Ecological comments

Planning Application No: **3/2012/0863**

Proposals: **Proposed erection of a CF 50kW wind turbine 39.65m high from blade to tip.**

Location: **Handlesteads**

Proposed Location of 50KW Wind Turbine

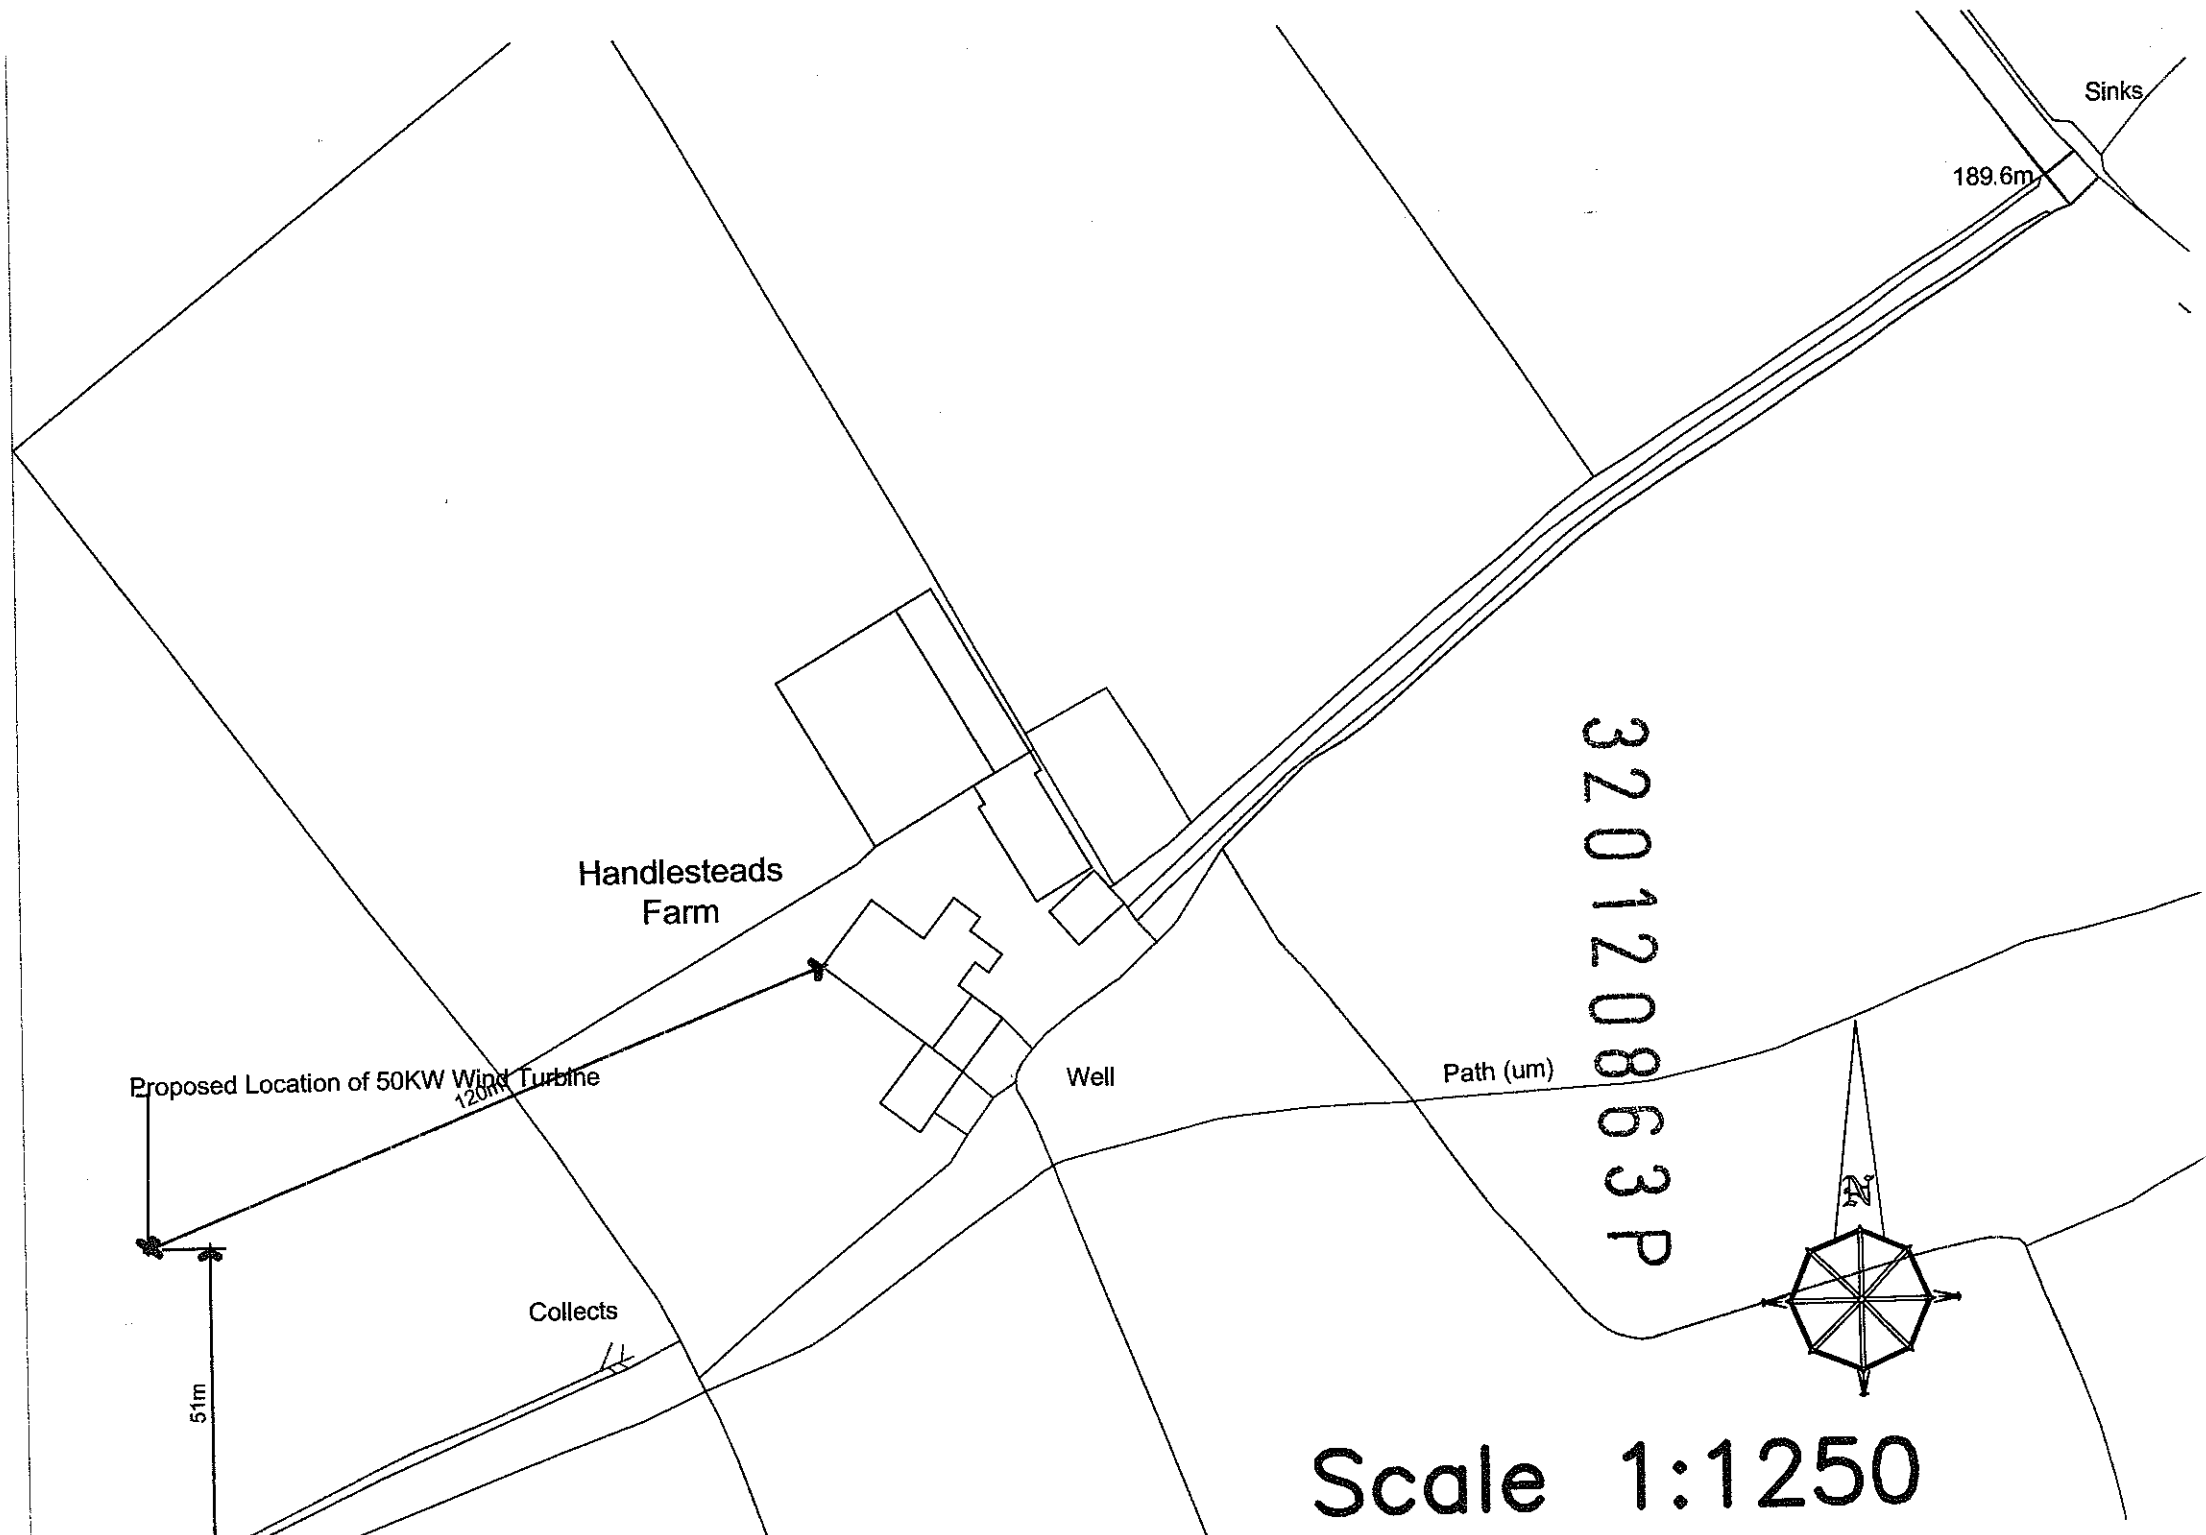
- The blade tips of the proposed turbine appear to fall within 50 metres of features that may be used by bats (such as the hedgerow line to the south east). Unless the turbine can be relocated to retain a buffer of at least 50m from blade tip to features with potential to be used by bats, and the applicant can provide information to demonstrate that this would be the case (using the calculations detailed in the Natural England Guidance note TIN051), further information will need to be provided before the application if determined (see below).

The blade tips of the proposed turbines appear to fall within 50m of features which may be used by bats (hedgerow to the south). In order to avoid impacts on bats, and the need for surveys/assessments, the turbine(s) should be relocated to maintain a buffer of at least 50m from blade tips to features which have the potential to be used by bats (such as trees, buildings, waterbodies, linear features such as hedgerows, tree lines, ditches and stone walls connecting suitable bat habitat, and other suitable foraging habitat etc) and the applicant should provide information to demonstrate that this would be the case (using the calculations detailed in the Natural England Guidance note TIN051).

If the turbine(s) cannot be re-located / it cannot be demonstrated that the turbine blade tips would not fall within 50m of features which may be used by bats, then bat survey(s) to establish likely impacts will need to be undertaken and submitted prior to determination of the application. Bat surveys should follow appropriate guidance (*Bat Surveys: Good Practice Guidelines* published by the Bat Conservation Trust, 2012) and be undertaken by a competent appropriately qualified person.
